# Planning Statement - Section 146B Alteration Request (ABP PA92.319013)

**Alterations to the permitted design of the replacement of  
renewable energy plant**

## **Medite DAC Europe**

12 August 2025

DEVELOPMENT AREA 1

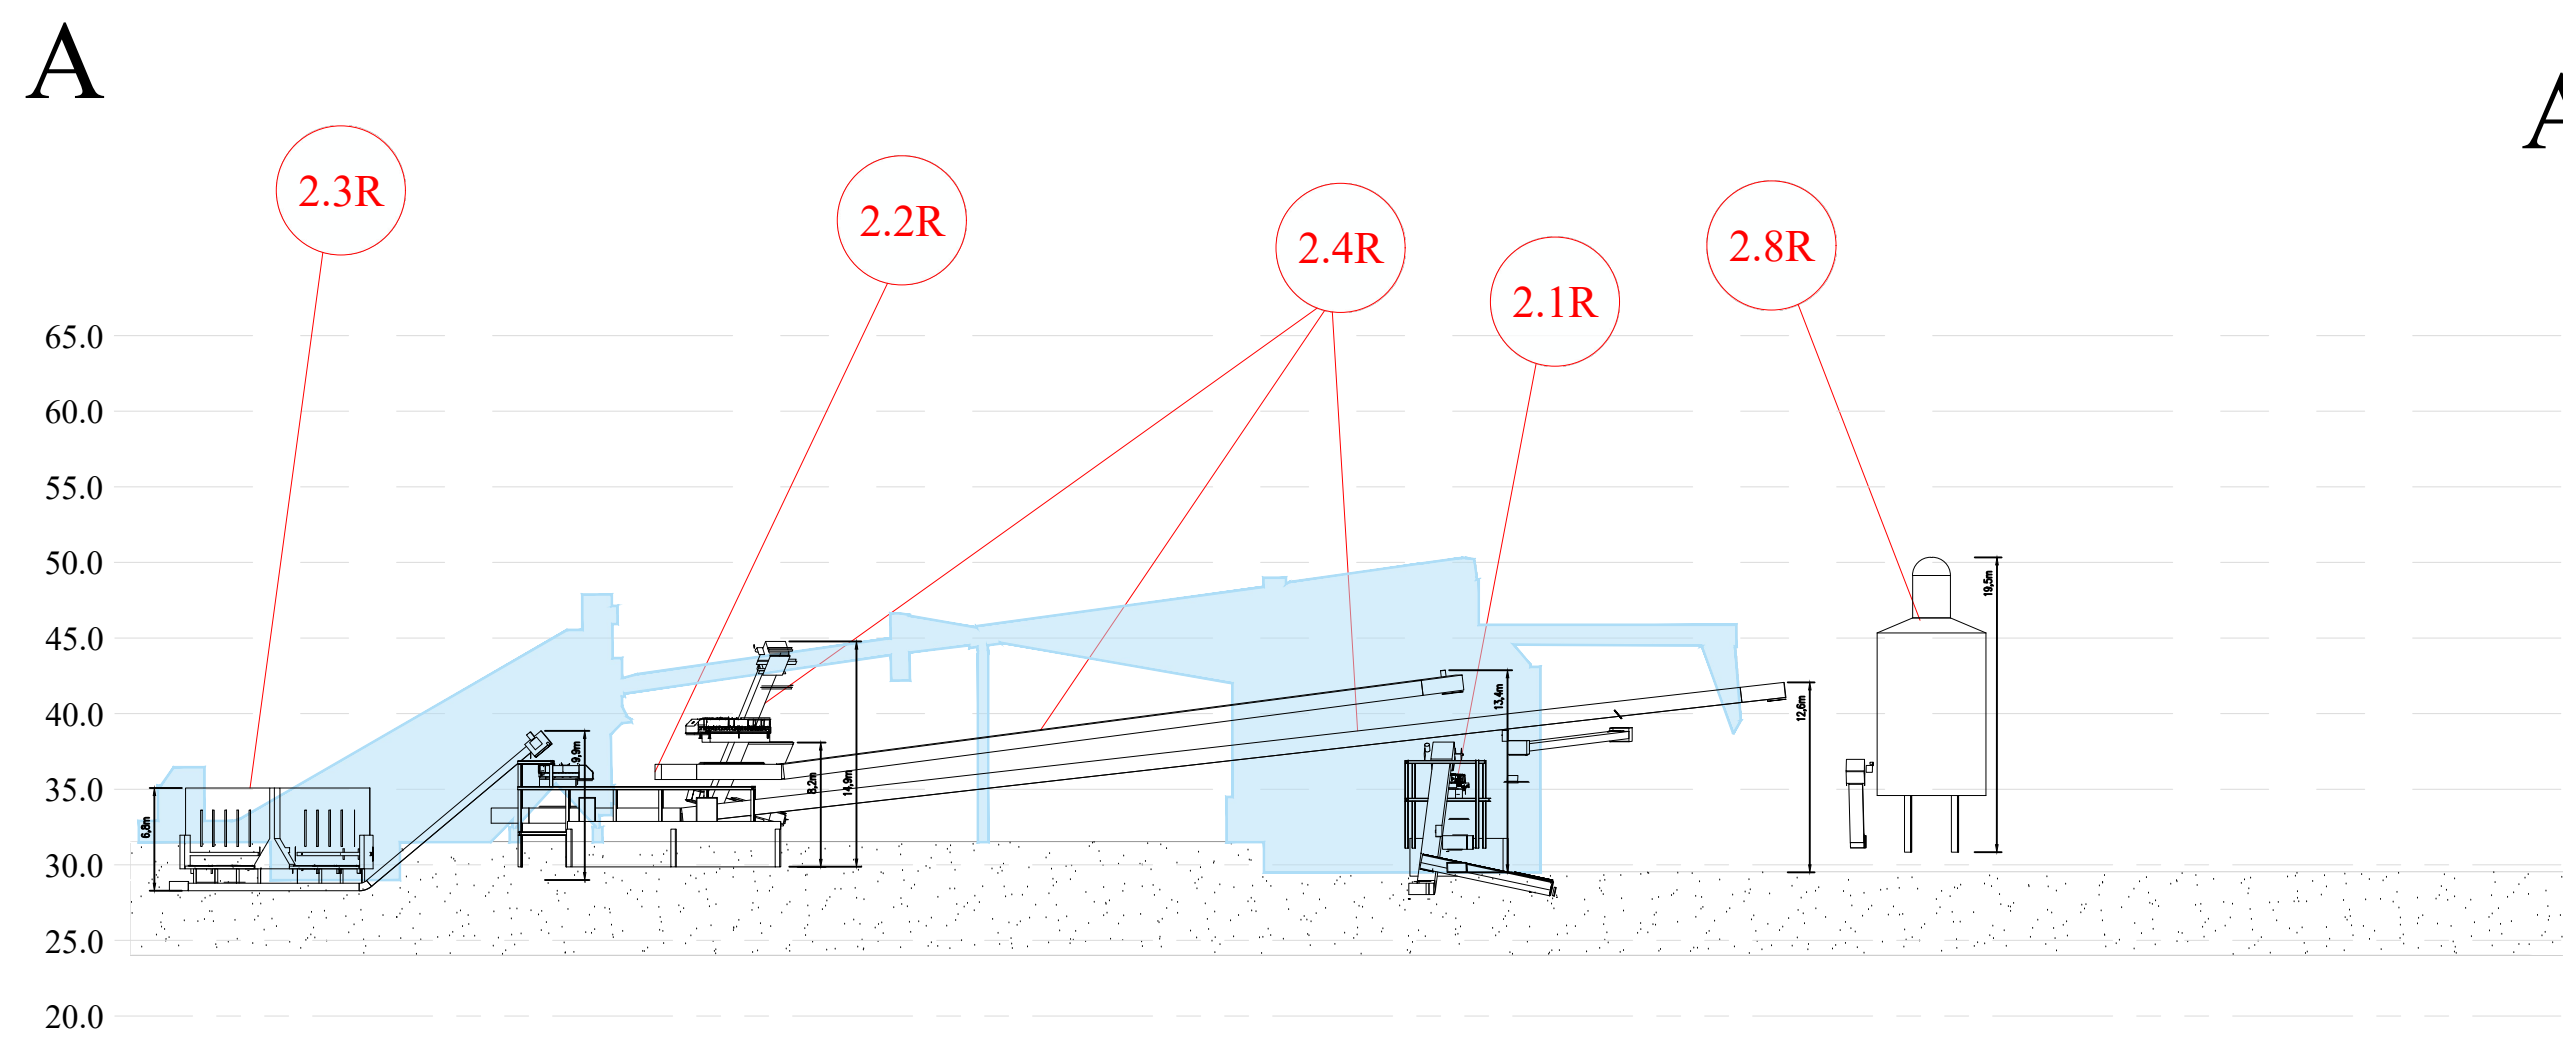
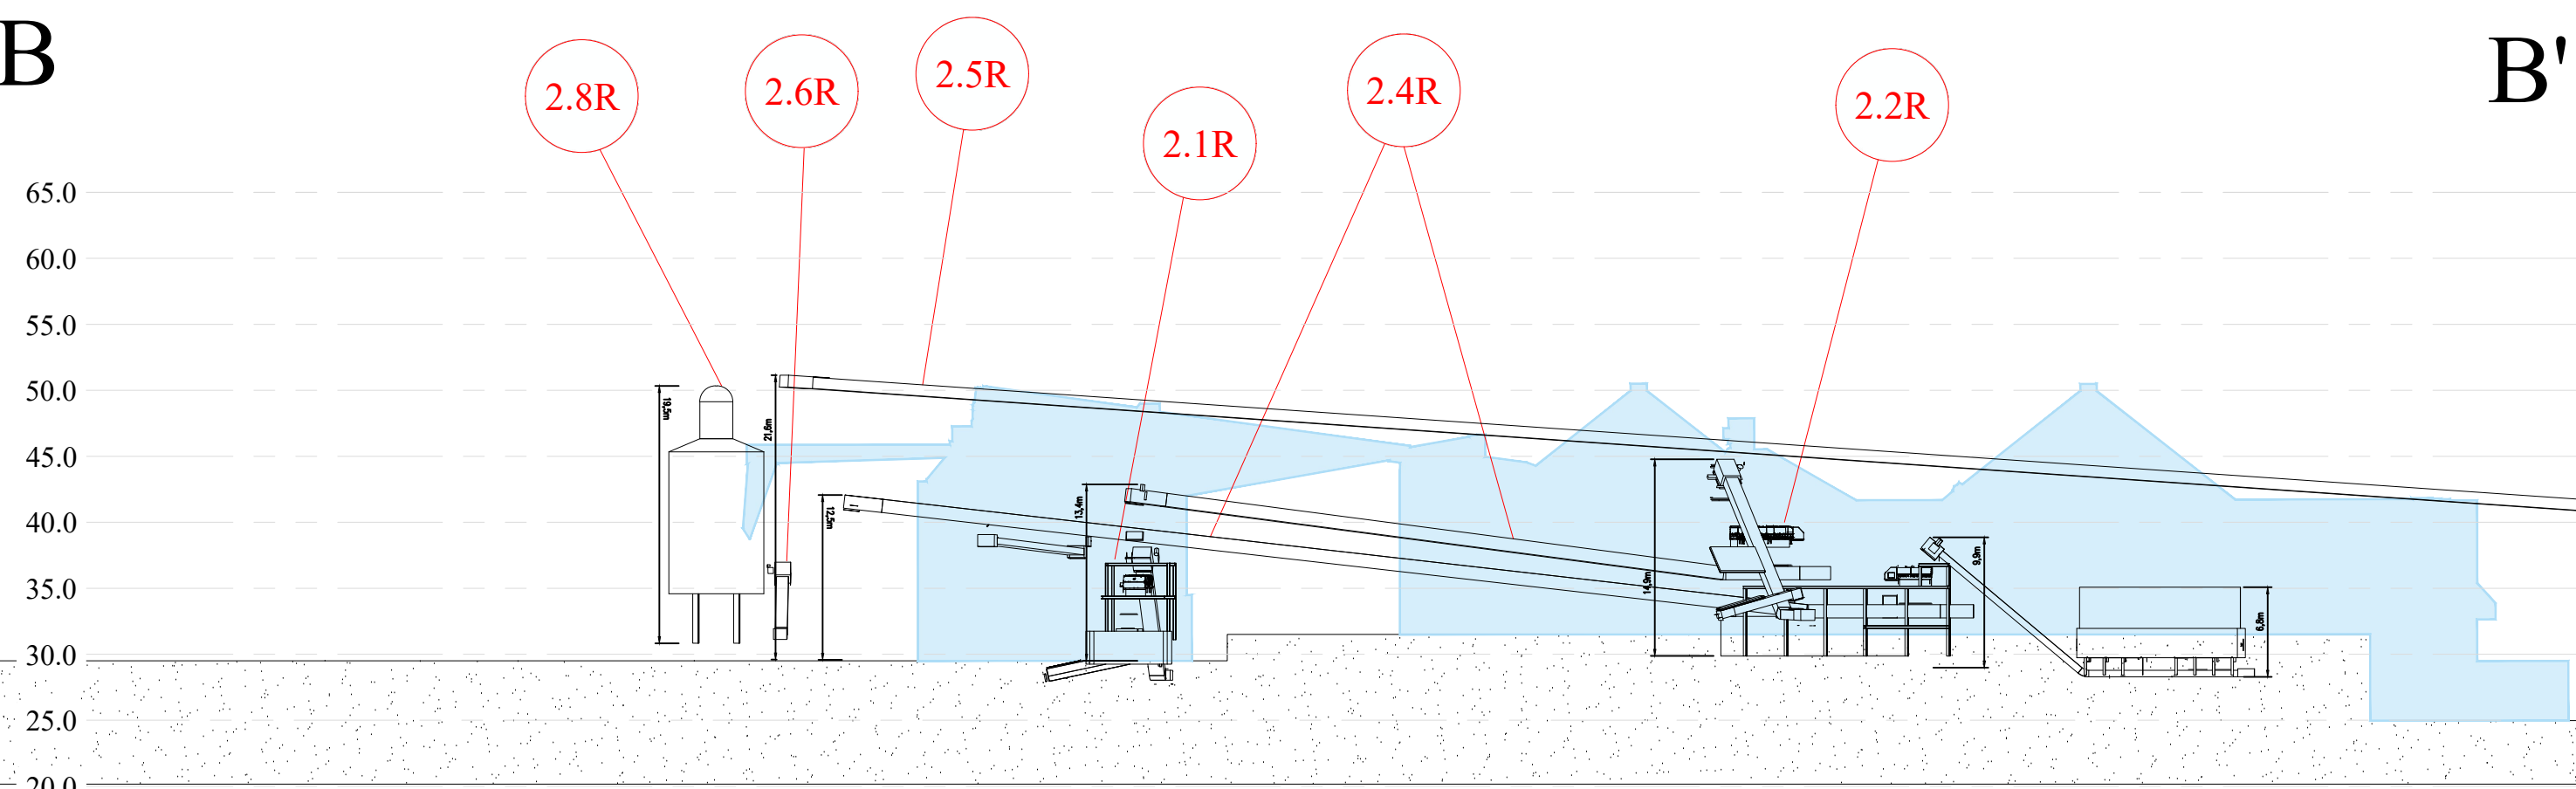
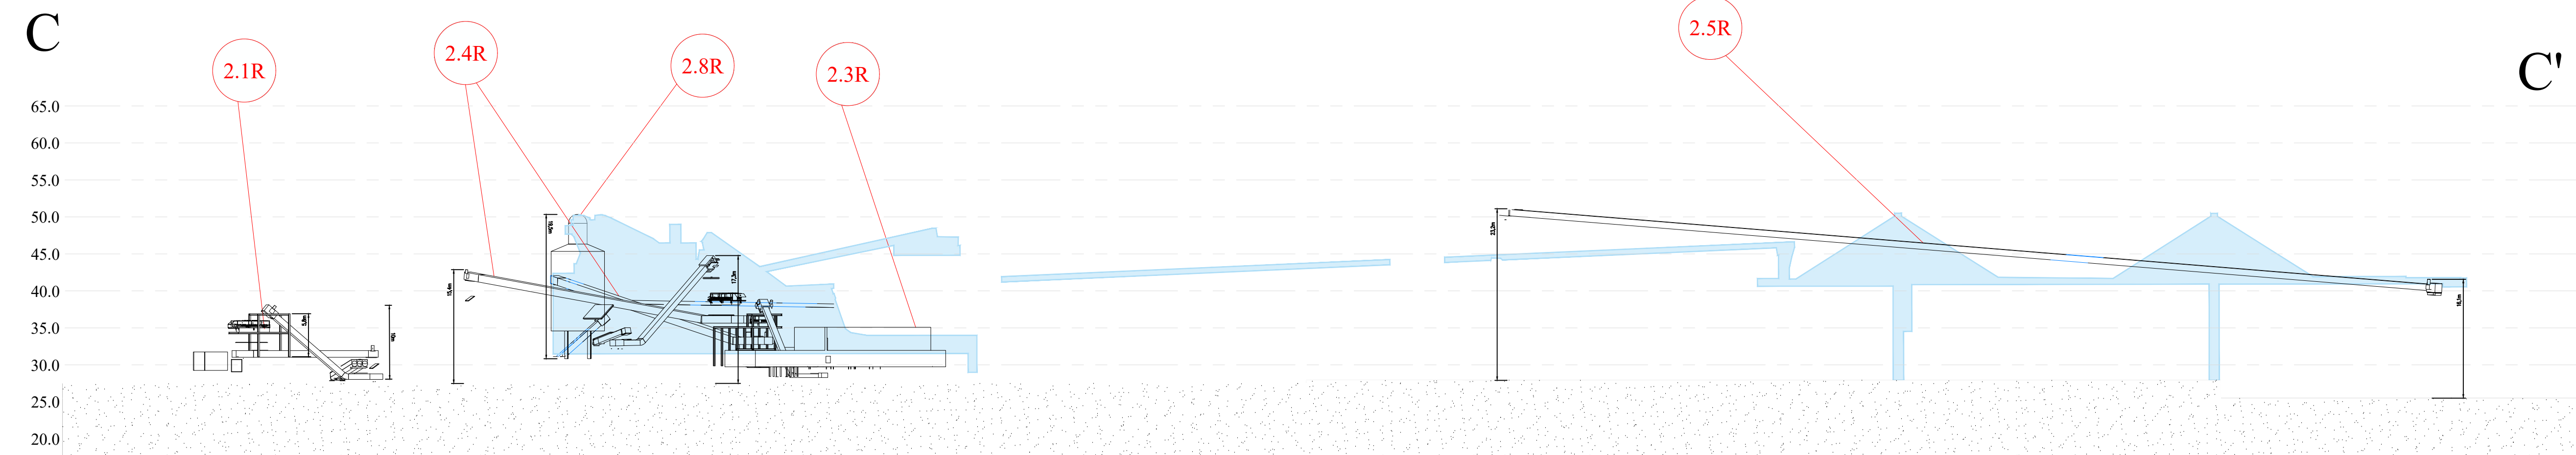
No.	Permitted Item	Description	No. (R)	Proposed Alteration Dimensions	Summary of Alterations
ITEM 2.1	1 x Fuel Reception Units 7.0m x 5.0m x 5.5mH Area = 35m <sup>2</sup>	A new Fuel Reception unit will be constructed adjacent to the existing Fuel Reception. The existing hopper that is currently in this location will be removed. The Fuel Reception Units will facilitate the unloading of HGV's delivering fuel chip to site in walking floor trailers. The HGV's will reverse the trailers into position and evacuate the walking floor trailer into the reception unit that gathers and conveys the material onwards. The units are covered to minimise any potential dust emissions.	ITEM 2.1R	Fuel Reception Units altered dimensions to 7.3m x 4.9m x 5.8mH  <b>Difference in dimensions:</b> +0.3m x -0.1m x +0.3mH	<b>Proposed Area:</b> 35.77m <sup>2</sup>  <b>Area difference:</b> slight increase in area of +0.77m <sup>2</sup>  <b>Relocated</b> to location of 7.5m northeast of permitted Fuel reception unit.

ITEM 2.2	Fuel infeed hopper 3.0m x 6.2m x 5 m H Area = 18.6m <sup>2</sup>	The Fuel infeed Hopper will facilitate the introduction of fuel wood chipped onsite into the fuel storage system by means of a front-end loader.	ITEM 2.2R	Fuel infeed hopper altered dimensions to 2.3m x 3.7m x 8.2mH  <b>Difference in dimensions:</b> -0.7m x -2.5m x +3.2mH	<b>Proposed Area:</b> 8.5m <sup>2</sup>  <b>Area difference:</b> reduction in area of -10.1m <sup>2</sup>  Realigned to match process/operational requirements and relocated to more suitable location of

No.	Permitted Item	Description	No. (R)	Proposed Alteration Dimensions	Summary of Alterations
					35.13m east of permitted Fuel infeed hopper
ITEM 2.3	Walking Floor Infeed System 24m x 18.6m x 5.0m H Area = <del>202.3</del> <sup>3</sup> 446.4m <sup>2</sup>	The Walking Floor infeed system facilitates the introduction, buffer storage, and mixing of production residue fuels into the fuel storage and conveying system by means of a front-end loader.	ITEM 2.3R	Walking Floor Infeed System altered dimensions to 27.3m x 12.2m x 6.8mH  Difference in dimensions: +3.3m x -6.4m x +1.8mH	<b>Proposed Area:</b> 333.0m <sup>2</sup>  <b>Area difference:</b> reduction in area of -113.34m <sup>2</sup>  Realigned and sized to match process/operational requirements. Relocated to more suitable location 15.7m north of permitted walking floor infeed system.

ITEM 2.4	Conveying Systems #1 (Into Storage Building) Approx 200m length of conveying Height Varies from ground to max of 20.8m, refer to drawings. Conveying System #1 Area = 520m <sup>2</sup>	The conveying systems will consist of both belt and chain conveyors (all covered to minimise dust emissions) to transport fuel from the Fuel Infeed Hopper (Item 2.3) and from the Walking Floor Infeed System into the Fuel Storage Building (Item 1.19).	ITEM 2.4R	Conveying Systems #1 (Into Storage Building) Consists of 3 lengths of conveyors of approx. length of 16.2m, 56.8m and 106.9m respectively = 179.9m length of conveying  Difference in dimensions: reduced by -20.1m in length  Layout streamlined to match process/operational requirements	<b>Proposed Area:</b> 207.4m <sup>2</sup>  <b>Area difference:</b> due to shorter length and reconfigure of conveyor; the area of the conveyors is reduced from 520m <sup>2</sup> to 207.4m <sup>2</sup> = Reduction in area of 312.6m <sup>2</sup>

No.	Permitted Item	Description	No. (R)	Proposed Alteration Dimensions	Summary of Alterations
ITEM 2.5	Conveying Systems #2 (from Storage Building to energy Systems)  Line 1 Energy Plant Approx 266m length of conveying Height Varies from ground to max of 22.5m, refer to drawings. Conveying System #2 Area = 245* <sup>4</sup> 295.9m <sup>2</sup>	The conveying systems will consist of both belt and chain conveyors (all covered to minimise dust emissions) to transport fuel between from the fuel storage building (item 1.19) to the respective energy systems. This will include an existing conveyor that will be relocated.	ITEM 2.5R	Conveying Systems #2 (from Storage Building to energy Systems) to ITEM 2.5 to Line 1 Energy Plant  Reduced to approx. 170m length of conveying Height Varies from ground to max of 23.2m  Difference in dimensions: length reduced by -96m due to utilising existing conveyors and slight increase of +0.7m in height	<b>Proposed Area:</b> 165.0m <sup>2</sup>  <b>Area difference:</b> due to utilising existing of conveyor; the area of the conveyors is reduced from 295.9m <sup>2</sup> to 165.0m <sup>2</sup> = Reduction in area of -130.9m <sup>2</sup>  Conveyor alignment altered from refiner building to energy plant

ITEM 2.6	Line 2 Energy Plant Approx 44m length of conveying Height Varies from ground to max of 20.9m, refer to drawings. Conveying System #2 Area = 77.5m <sup>2</sup>	The conveying systems will consist of both belt and chain conveyors (all covered to minimise dust emissions) to transport fuel between from the fuel storage building (item 1.19) to the respective energy systems. This will include an existing conveyor that will be relocated.	ITEM 2.6R	Line 2 Energy Plant  Approx 10m length of conveying Height Varies from ground to max of 11.0m  Conveying System #2 Difference in dimensions: reduction of -33.0m in length and -9.9m in height	<b>Proposed Area:</b> 11.0m <sup>2</sup>  <b>Area difference:</b> the area will be reduced by -66.5m <sup>2</sup>  Conveying Systems #2 (from Storage Building to energy Systems) re-configured and utilise existing conveyors.

ITEM 2.7	Pneumatic (Dry Fuel) Systems Pneumatic Transport Ducts	The existing pneumatic conveying systems, including blowers, fans & filters to capture & transport production residues will undergo		Pneumatic (Dry Fuel) Systems  Item 2.7 Pneumatic

No.	Permitted Item	Description	No. (R)	Proposed Alteration Dimensions	Summary of Alterations
	<p>#1 Length = 161.5m x Ø150mm pipe</p> <p>#2 Length = 202.9m x Ø150mm pipe</p> <p>Total length = 364.4m</p>	<p>some alterations and additions to facilitate the proposed development.</p> <p>The existing Line 2 Sander Dust &amp; Saw Dust pneumatic extraction systems will be modified to provide separate systems for sander dust and saw dust. This will incorporate additional pneumatic conveying plant and infrastructure to transport the saw dust to the existing sander dust silos. A new Sander Dust Silo Ø=6.0M x H=16M &amp; associated filter plant (Item 3.7) will be located in Development Area 2, adjacent to the proposed Line 1 Energy System. The Sander Dust Silo will receive pneumatically conveyed fuel dust from the existing on sander dust silos and will discharge material into the Line 1 Energy Plant as fuel.</p> <p>The existing Line 1 Saw Dust pneumatic extraction system will be modified to send the saw dust to either (by means of a divert gate) the proposed Edge Trim Silo (see above) Or the proposed Sander Dust Silo (also see above).</p> <p>The existing Line 1 Sander Dust Silos (2No.) discharges will be modified to deliver sander dust to the new Sander dust silo proposed adjacent to the proposed Line 1 Energy System. The Ø150mm pipe that currently connects the existing Line 1 Sander Dust Silos to the existing Line 1 Energy System will be redirected to the proposed new sander dust silo.</p>	ITEM 2.7R	<p>Transport Ducts</p> <p>#1 Length = 161.5m x Ø150mm pipe</p> <p>#2 Length = 257.2 m x Ø150mm pipe</p> <p><b>Difference in dimensions:</b></p> <p>#2 Length has increased by +54.3m to align with Item 3.8R Line 1 Thermal Fluid Pipping</p>	<p><b>Proposed Length: 418.7m</b></p> <p><b>Length difference: an increase of +54.3m</b></p>

No.	Permitted Item	Description	No. (R)	Proposed Alteration Dimensions	Summary of Alterations
ITEM 2.8	Edge Trim Silo Ø=5.6m x H= 19.5m Area = 6.2m x 6.2m = 38.4m <sup>2</sup>	The existing Edge Trim System will be modified by dismantling and removing the existing Edge Trim Silo and associated filter plant (Item 1.26) (Air Emission A2-20) and constructing a new Edge Trim Silo Ø=5.6m x H= 19.5m, (Item 2.8) and associated filter plant adjacent to the fuel storage building. The Ø150mm pipe that currently connects the production process to the existing Edge Trim Silo will be redirected to the new Edge Trim Silo (Item 2.7). The discharge system within the new Edge Trim Silo will deposit the material into the fuel storage system conveyors. The alterations will include the pneumatic conveying plant and infrastructure to transport the edge trim to the new silo and the silo discharge system to deposit the material into the fuel storage system conveyors.	ITEM 2.8R	Edge Trim Silo Ø= 7.2m x H= 19.5m  Difference in dimensions: +0.4m x 0mH	<b>Proposed Area:</b> 51.8 m <sup>2</sup>  <b>Area difference:</b> an increase of +13.4m <sup>2</sup>  Relocated to more suitable location of 37.3m east of permitted Item 2.8 Edge Trim Silo
